City of Portland, Maine - Building or Use Permit Application

Permit No: 02-0997	Issue Date: SEP 18 2002	CBL: 389 B009001
-----------------------	----------------------------	---------------------

Location of Construction: 104 Carter St	Owner Name: Thomas Timothy A &	Owner Address: 104 Carter St	Phone: 207-797-0721
Business Name:	Contractor Name: Applicant	Contractor Address: Portland	Phone:
Lessee/Buyer's Name	Phone:	Permit Type: Additions - Dwellings	Zone: R-2

Proposed Project Description: Construct a 22' x 22' addition	FIRE DEPT: <input type="checkbox"/> Approved <input type="checkbox"/> Denied <i>N/A</i>	INSPECTION: Use Group: R-3 Type: SB BORA 99
	Signature: <i>[Signature]</i>	Signature: <i>[Signature]</i>

New Addition BUILDING DIAGRAM

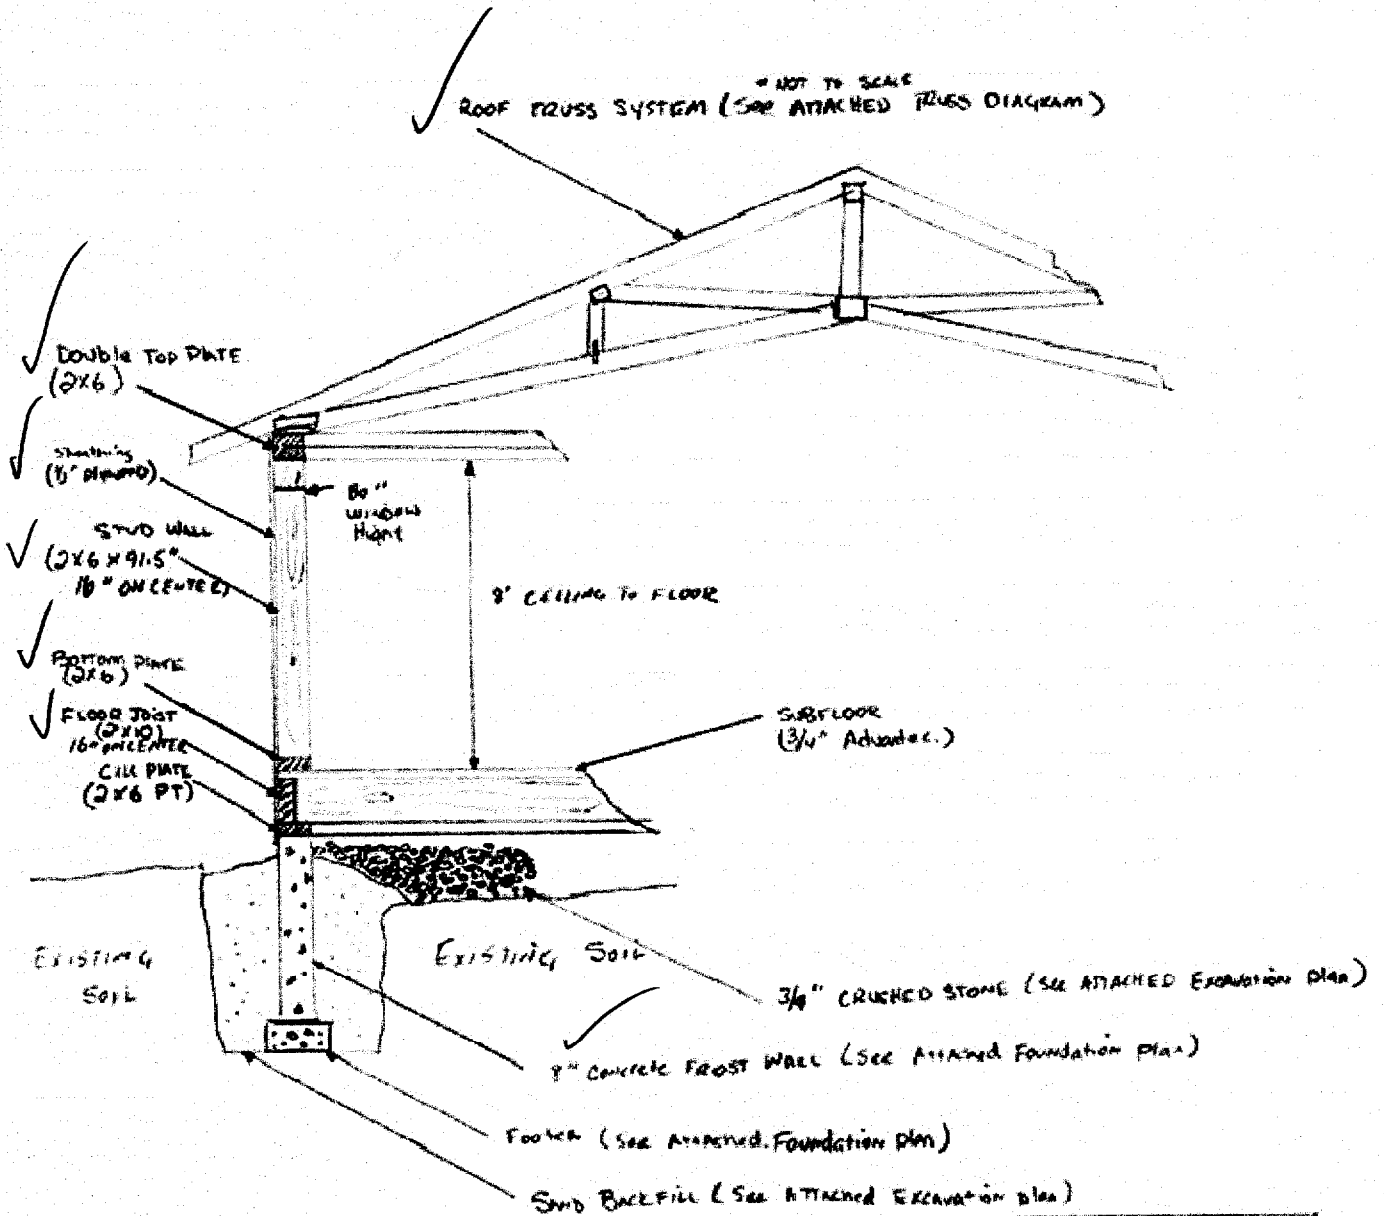
You must have an 18" x 24" minimum access opening to crawl space.

The frost wall must be minimum 4'-0" below grade.

Comment Date	Comment	Add	Delete	Save
09/11/2002	Spoke w/owner - went over everything needed. She said she'd submit tomorrow.			
09/11/2002	No dimensions on plot plan - inadequate structural plans. Called owner.			
09/17/2002	rec'd all info requested - ok to issue.

✓ Stairs: 7" rise – 11" tread – 2 stairs

✓ Window headers: (3) laminated 2" x 8" wood beams over every window and door for support.

✓ Floor support: (3) laminated 2" x 10" wood beams supported by foundation; runs side to side. Beam to be supported by (2) lolly columns every 7' on center. Lolly columns will be supported by cement footers.
